THE UNIVERSITY OF
SYDNEY

13 August 2020

Re: University of Sydney- Engineering and Technology Precinct – Mod 1 (SSD - 8636_Mod_2)

BON068: 1% AEP FLOOD LEVEL
AFFLUX PROPOSED - EXISTING

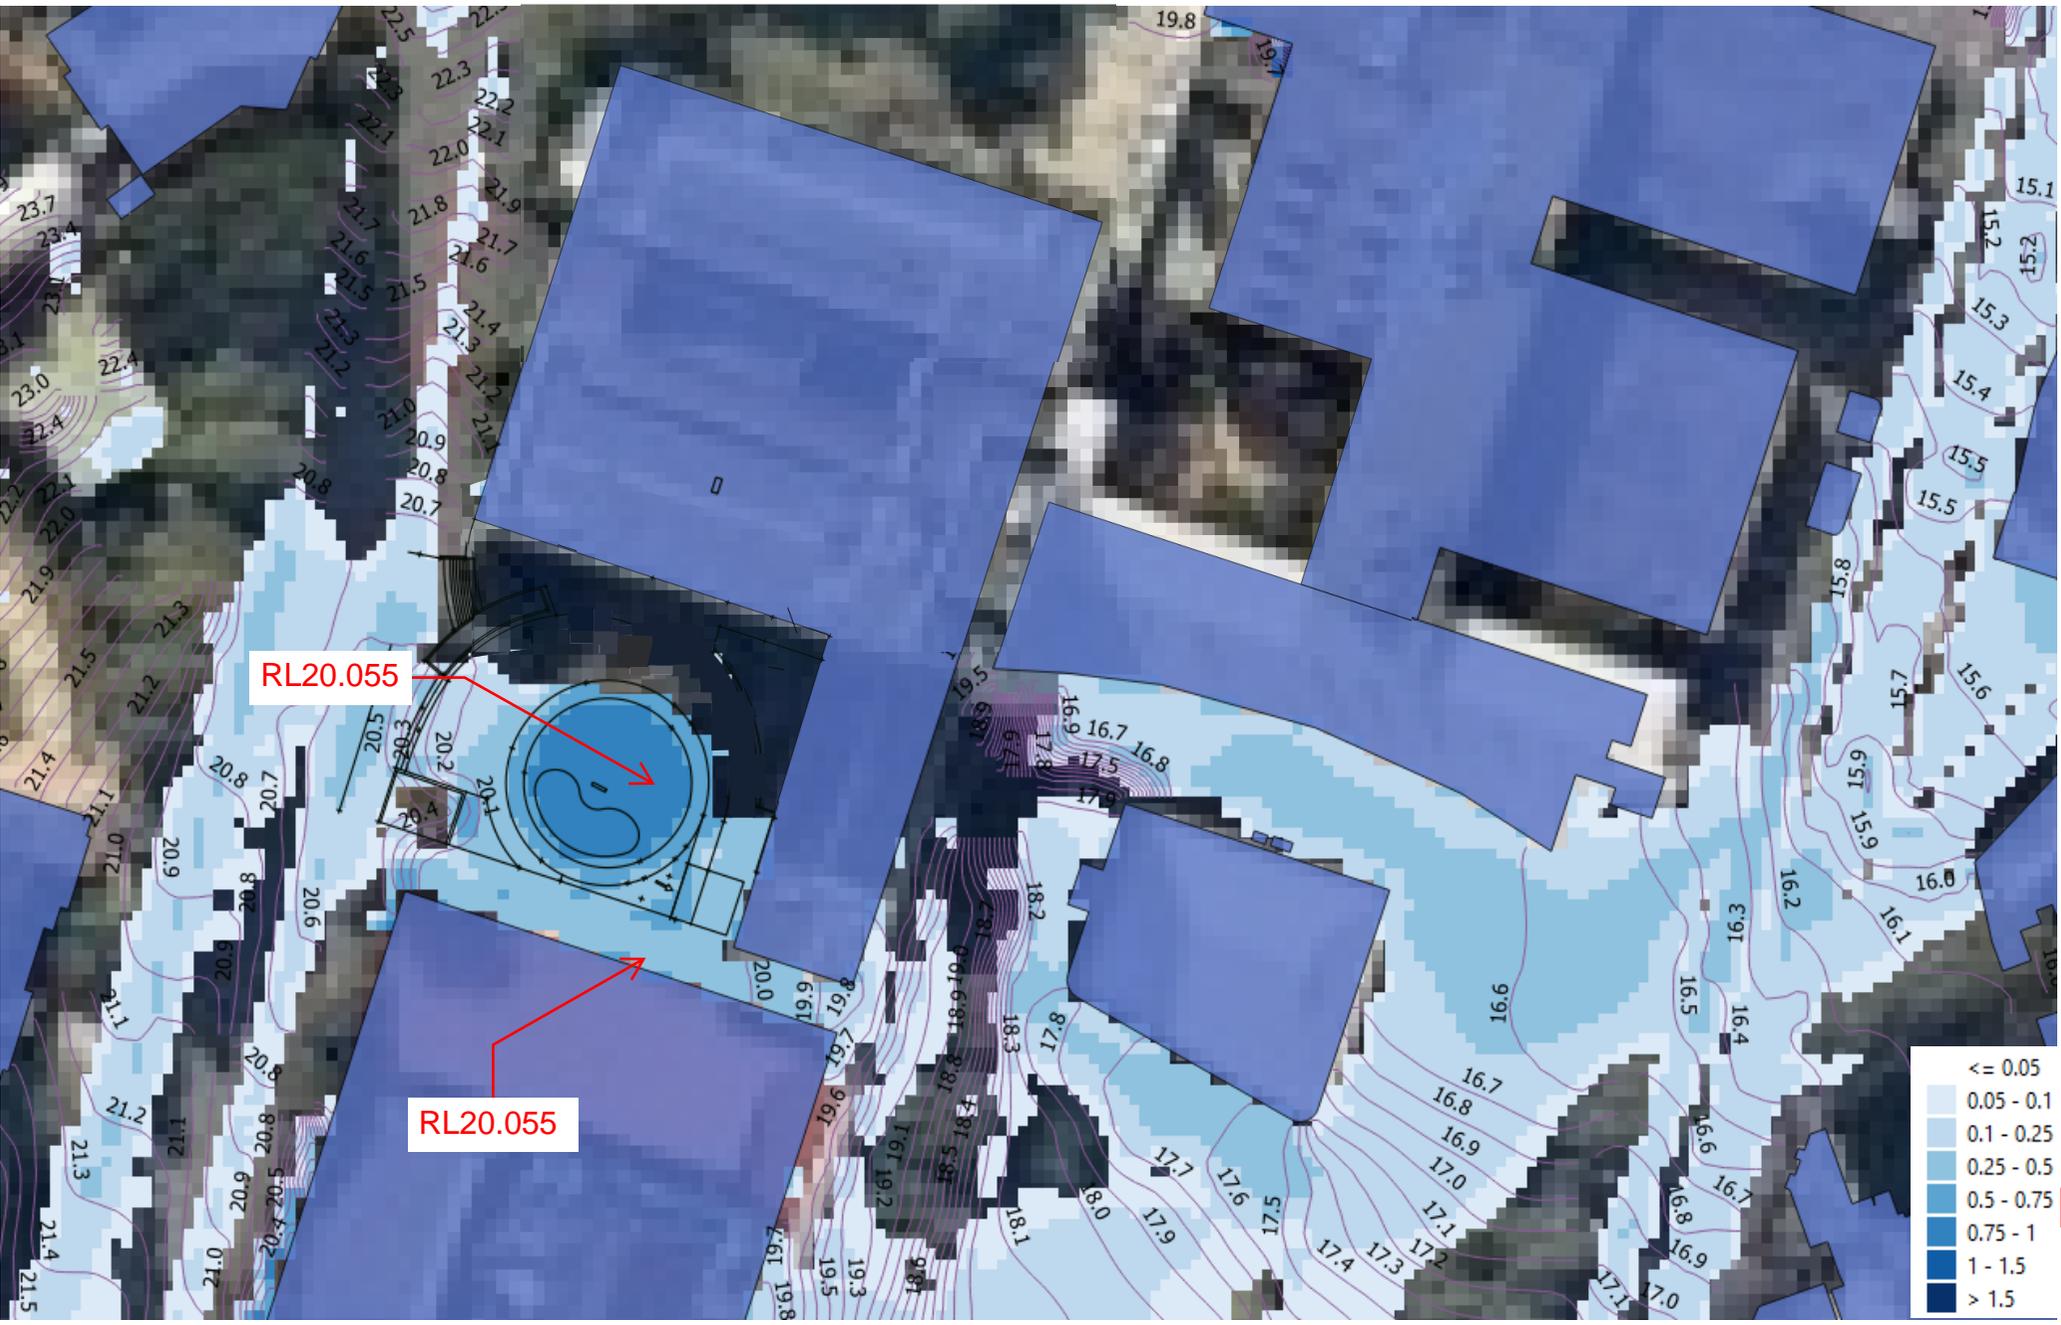
The flood model has been updated to include the revised basin and landscape design as shown in attachment 3 and changes described in detail below under Condition B38. To provide clarity regarding the changes to the flood level, the flood level afflux is shown below. The conclusion remains that there is no downstream impact traceable to the development. The flood depth that was previously shown outside the building has been addressed in our response to B38 below.

BON068: 1% AEP FLOOD HAZARD - DESIGN SCENARIO

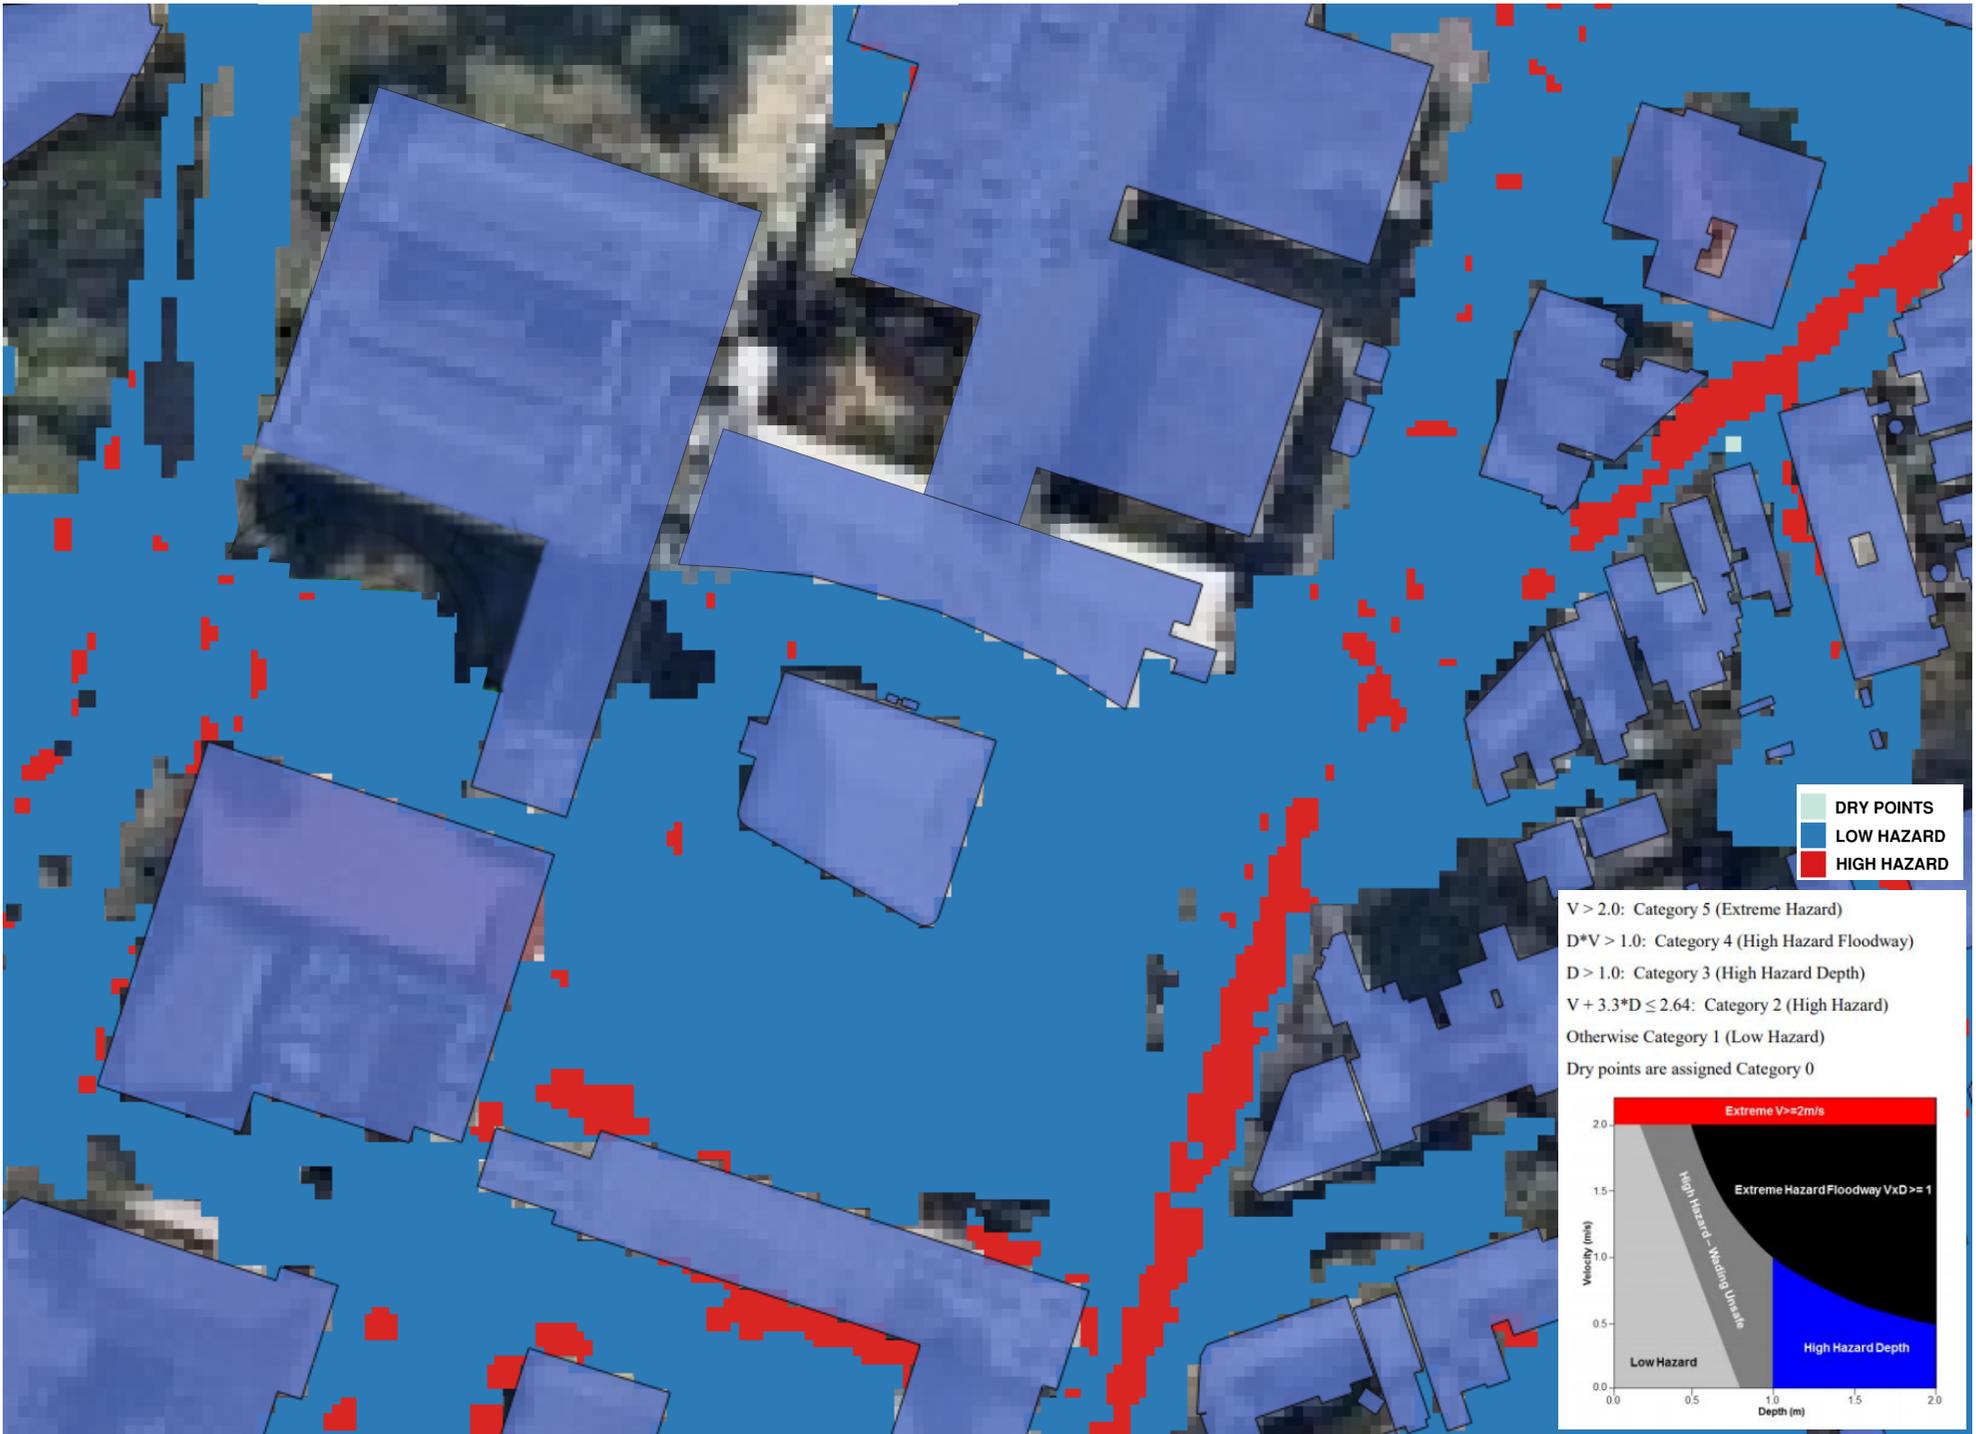
The flood hazard for the proposed altered design compared to the approved design has therefore been reduced from high to low (as categorised by NSW Flood plain development manual appendix L3, figure L1). Refer to the flood map extract below from attachment 2

Proposed plan - South Plaza

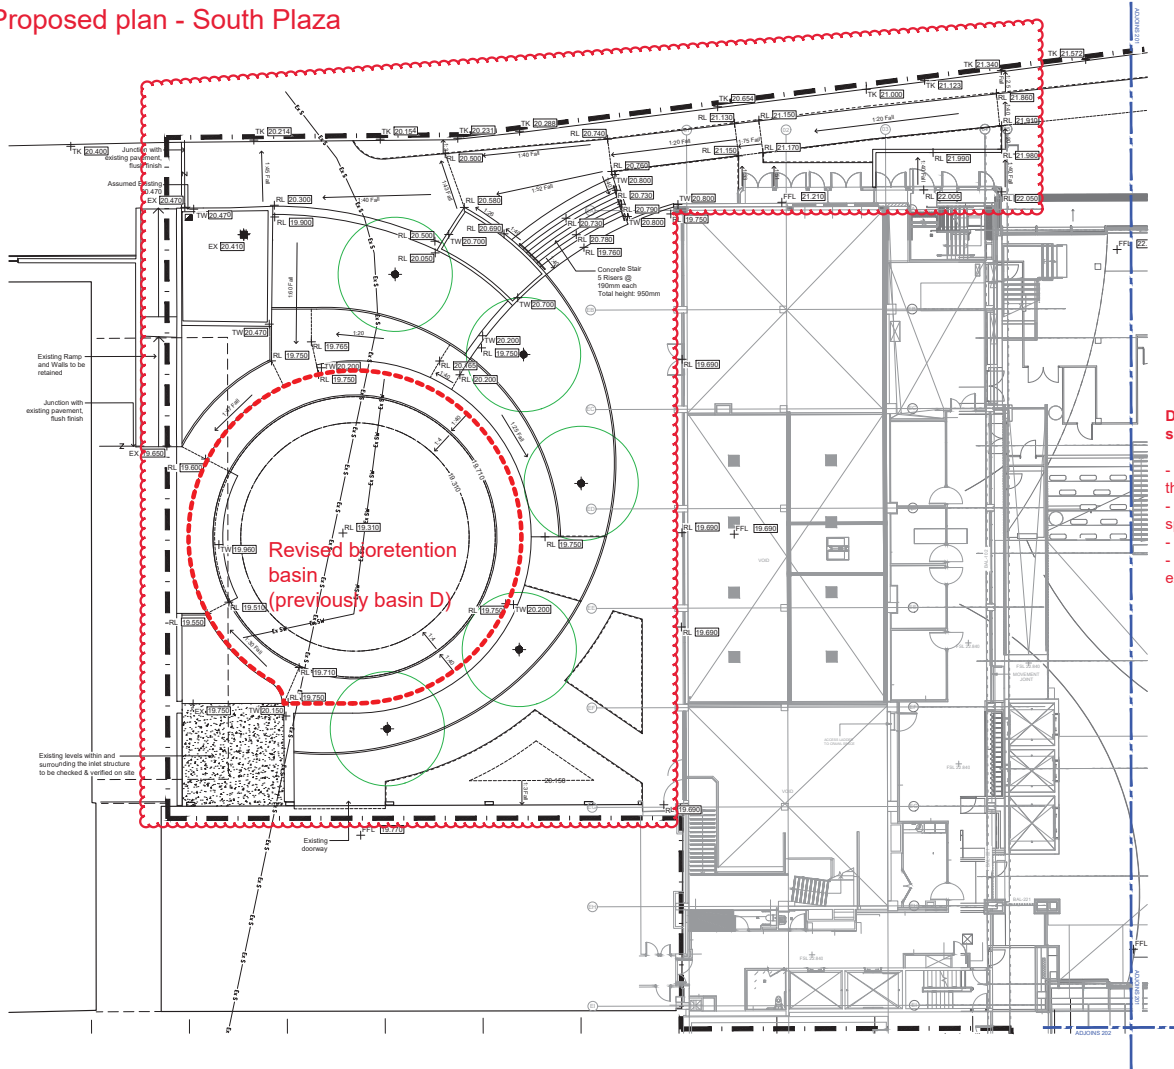
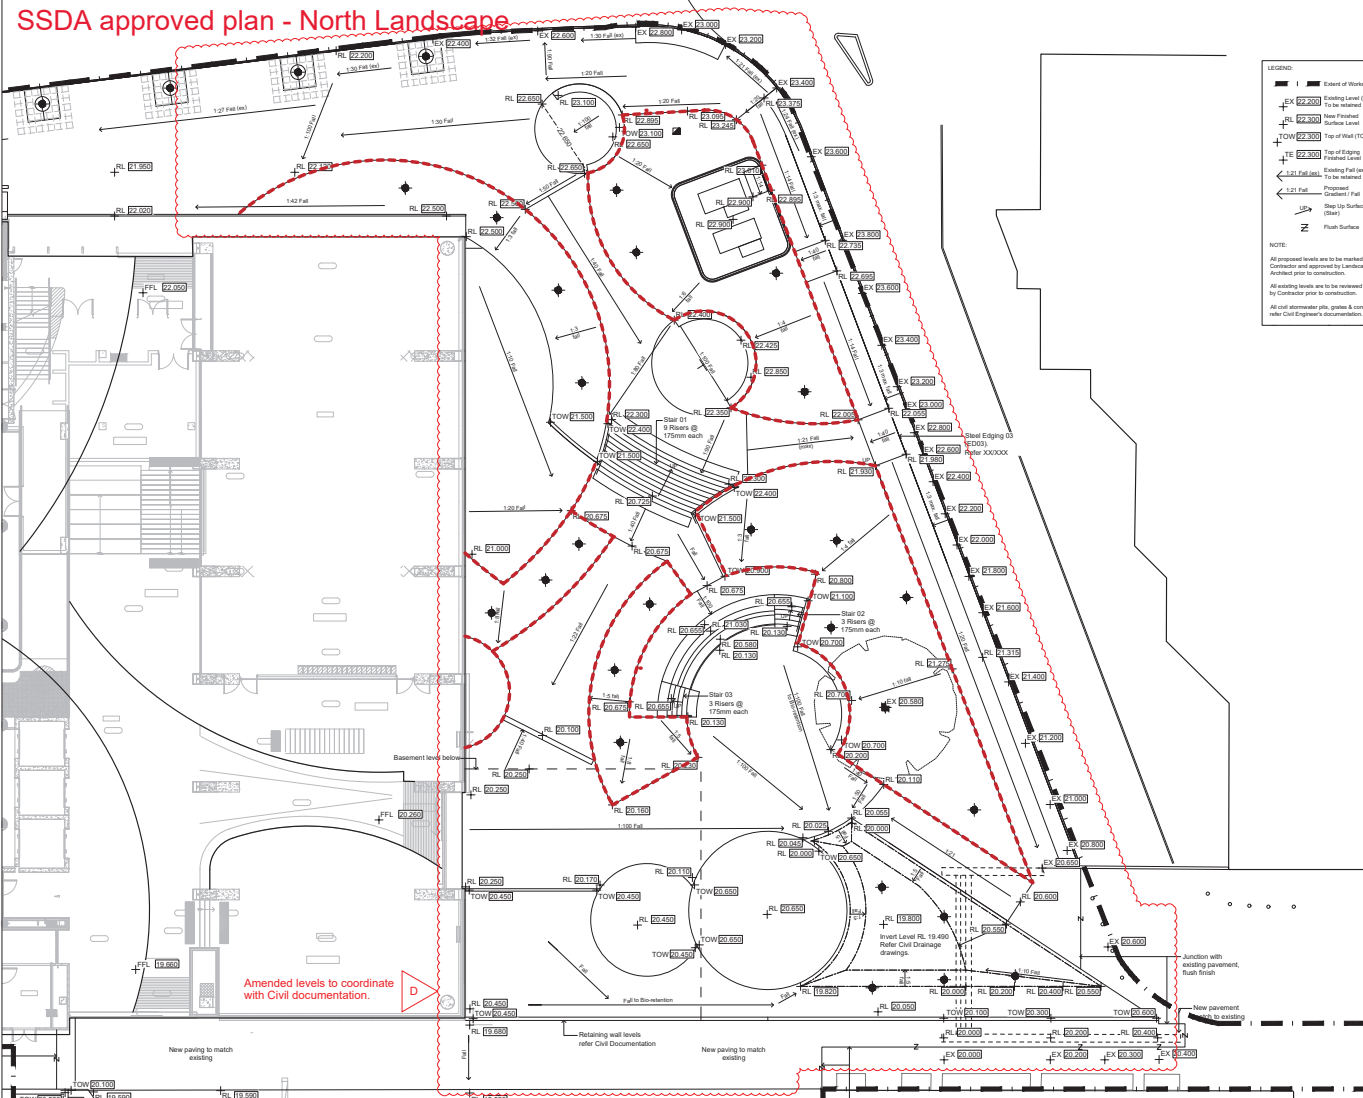
The University is seeking the deletion of condition B38 which requires a fence around Basin D. By improving the profile of the basin and the introduction of 1 in 4 batters to eliminate sharp changes in level and associated trip and fall hazards the need for fencing is avoided.

Regarding the first point for plans with sufficient levels and gradients, please refer to Attachment 3 for the revised plans of the basin. Note that the updated plans incorporate a seating wall which forms a 'wall around Basin D' as the engineering means to protect the building from a 1% AEP flood event. This wall provides the benefit of additionally separating pedestrians and pavement users from the basin. The

updated sketch includes the necessary detail along with sections to demonstrate the design is capable of achieving DDA Compliant equitable access.

As part of the redesign of the plaza, Basin D's profile and gradients have been raised to create a shallower basin whilst maintaining the OSD storage and water quality requirements for the development and maintaining no downstream impact to flooding.

Furthermore, the revised landscape design's improved circulation, gradients, levels and edging has improved circulation and further 'designed out' risks of tripping or falling into Basin D. The revised bio-retention basin D has incorporated batters that are traversable (maximum 1 in 4 grade) further designing out any ability to 'fall' into the basin.
